Written submission for Deadline 4, 13/01/2021

Richard Reeves, AP EA1N AFP 133 / IP 2002765

Responses, Questions, Corrections

RE The Applicants' Landfall Hydrogeological Risk Assessment 24/02/2021

| | 5 | 09/09/2019 | AB | Fifth Issue. | | | 1:2,500 | <div><div></div>Metres</div> <div>050100200</div> |

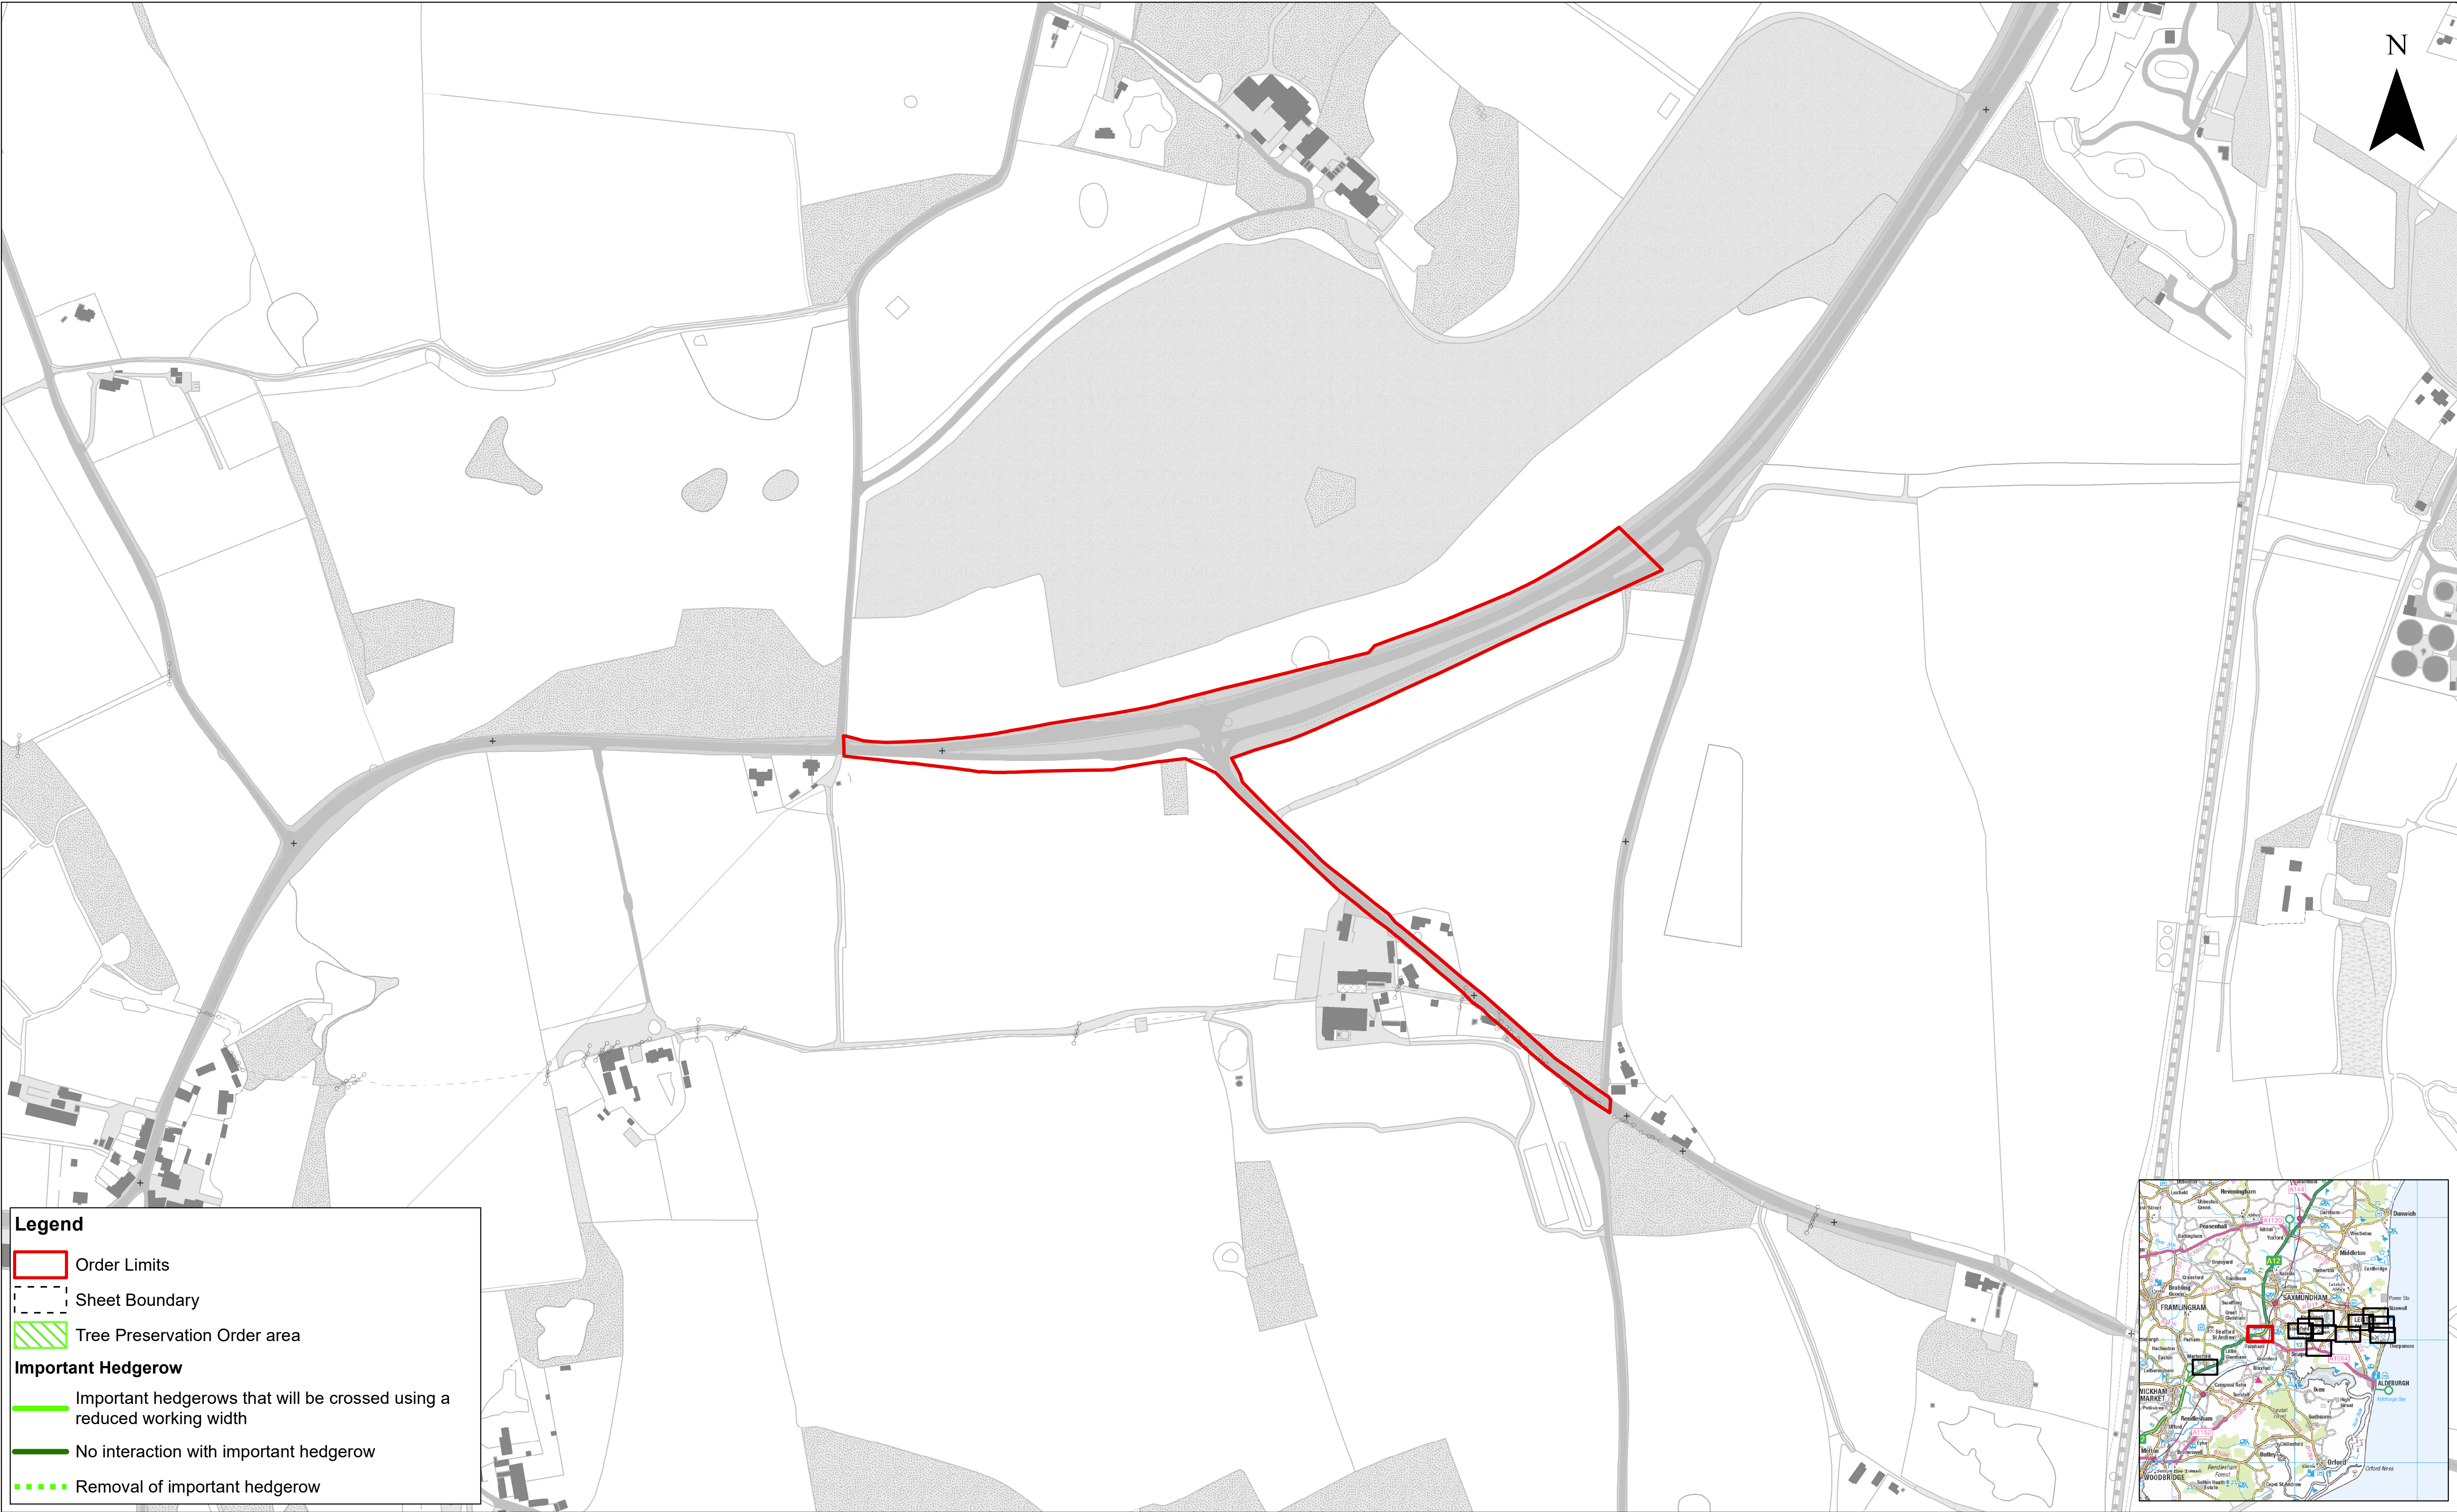
In Important Hedgerows 3 and 4 (scheduled for demolition) and the associated hedgerows linking and bordering plots 10;12;13;14 more than 40 species of wild flower have been recorded (cf my earlier submissions which include species recorded by Wardens volunteers and trustees over several decades). Amongst these flora are Red Valerian; Honeysuckle; Petunia; Sloe; Hawthorn; and numerous nectar-rich flowers. The species I name here are of particular relevance to several rare and protected species; three examples: the Hummingbird Hawk Moth; Lampyris Noctiluca (the Glowworm); Elephant Hawk Moth.
